# Access Review

Kambala School Sport, Wellbeing and  
Senior Learning Precinct

794 New South Head Road Rose Bay  
NSW 2029

SSDA Report

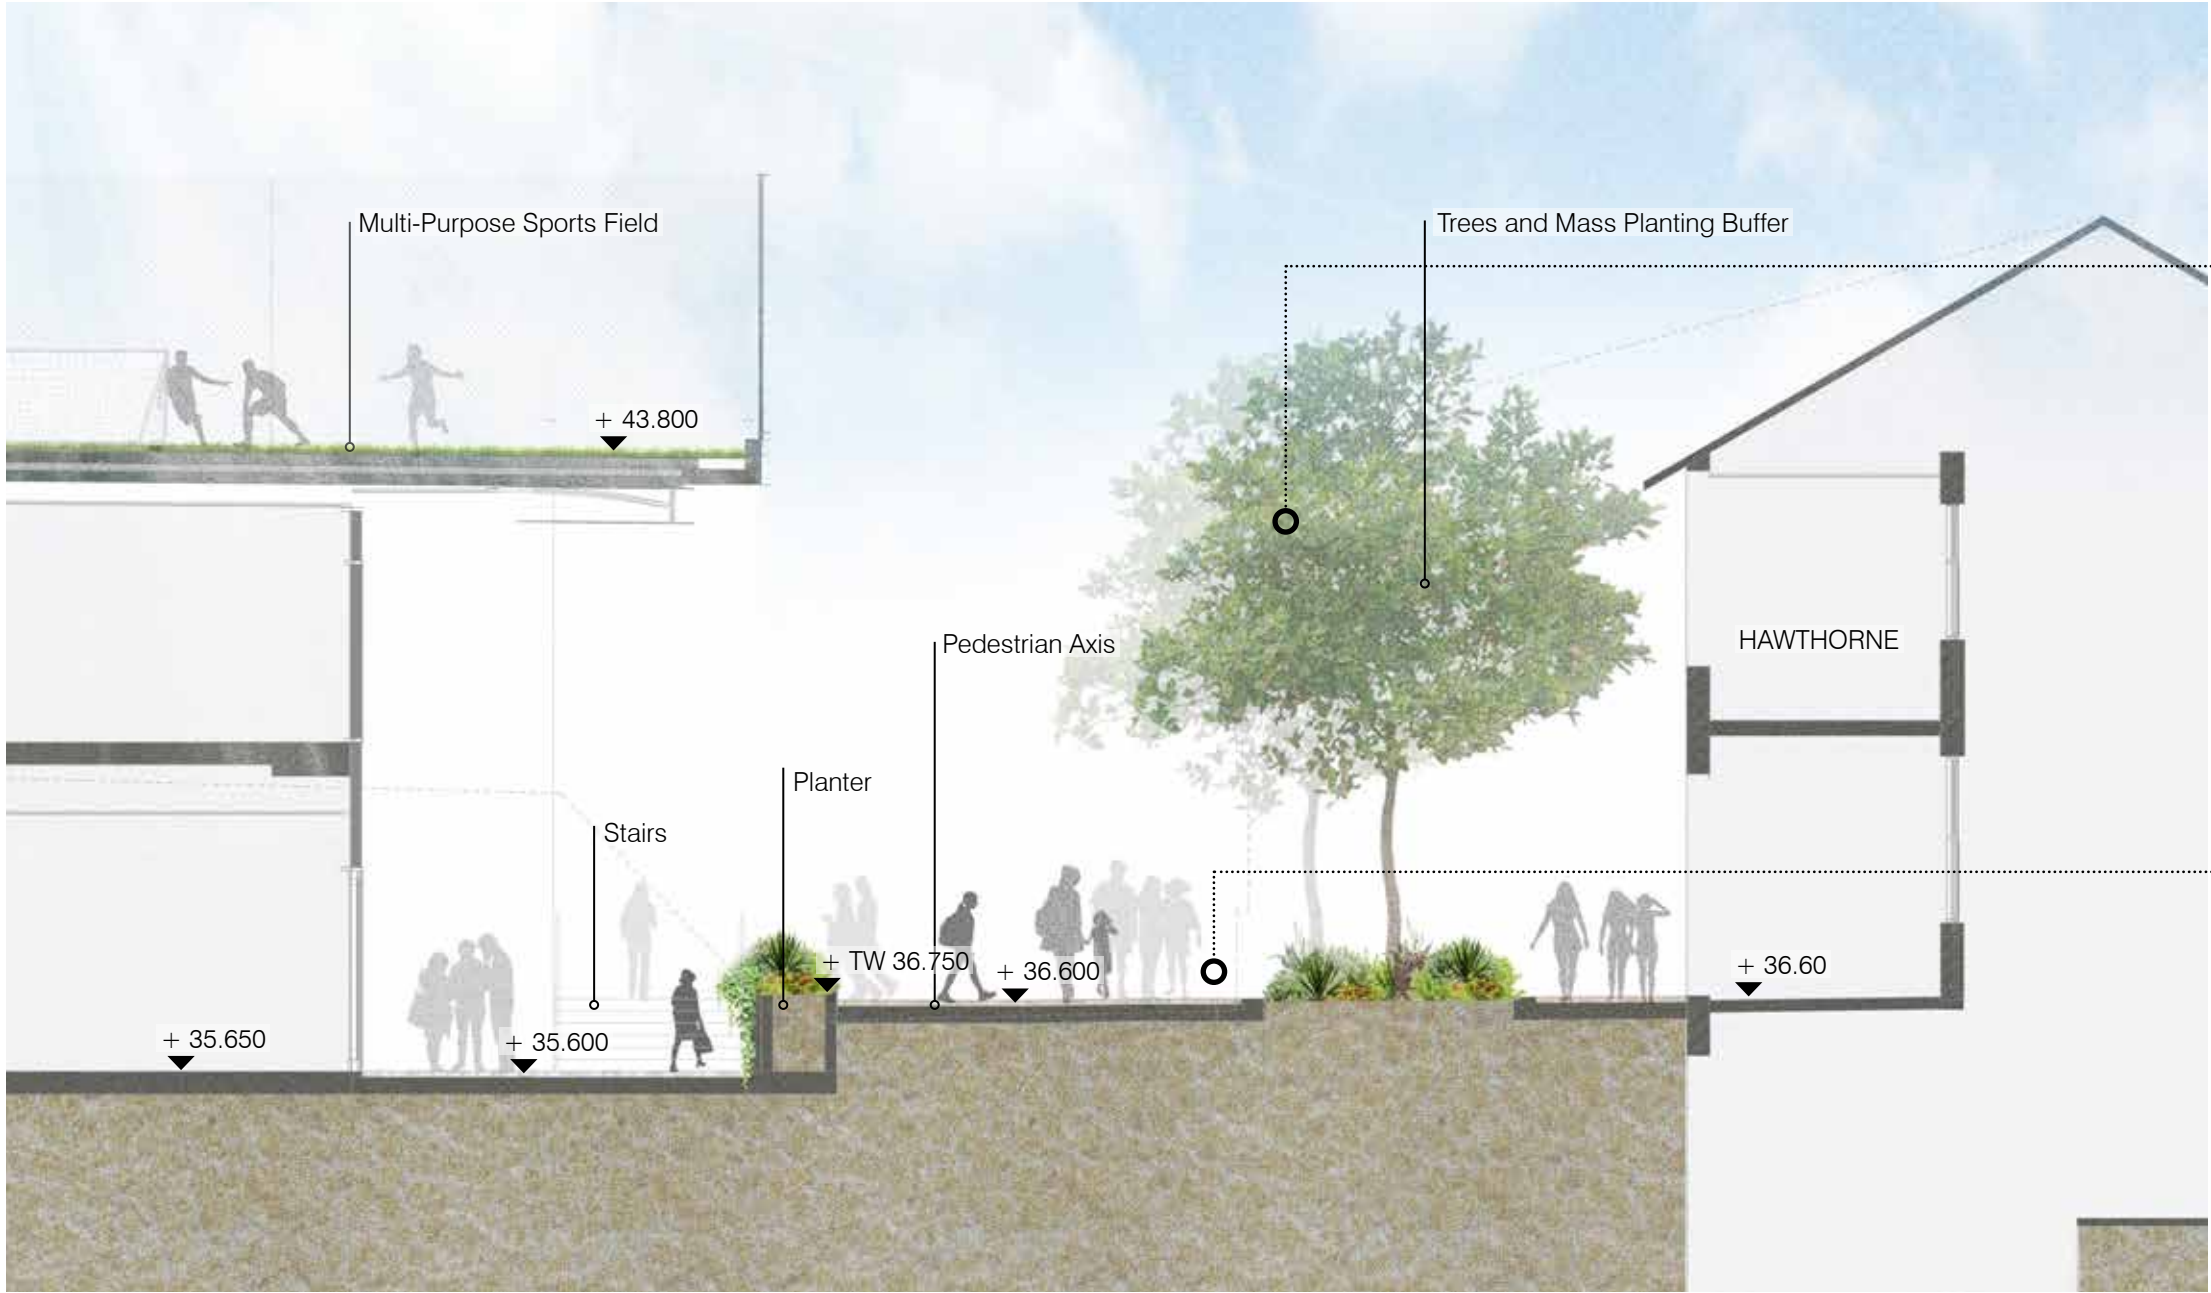
- External landscaped ramps (accessways with proposed maximum gradient 1:20) that form the accessible pedestrian axis between the buildings
- New ramp access into existing music building (eastern entrance)
- Vehicular ramp linking Level 2 with field level (not an accessible path of travel); lift access is provided to field level

- ii. Slip resistant surfaces on access ways that are traversable by people who use a wheelchair and those with an ambulant or sensory disability.
- iii. The series of 1:20 access ways to include features that comply with AS1428.1 including:

- a. Minimum clear width 1m and maximum length between landings of 15m
  - b. The floor or ground surface abutting the sides of the walkway to provide a firm and level surface of a different material to that of the walkway at the same level of the walkway, follow the grade of the walkway and extend horizontally for a minimum of 600 mm unless a kerb or kerb and handrail is provided.
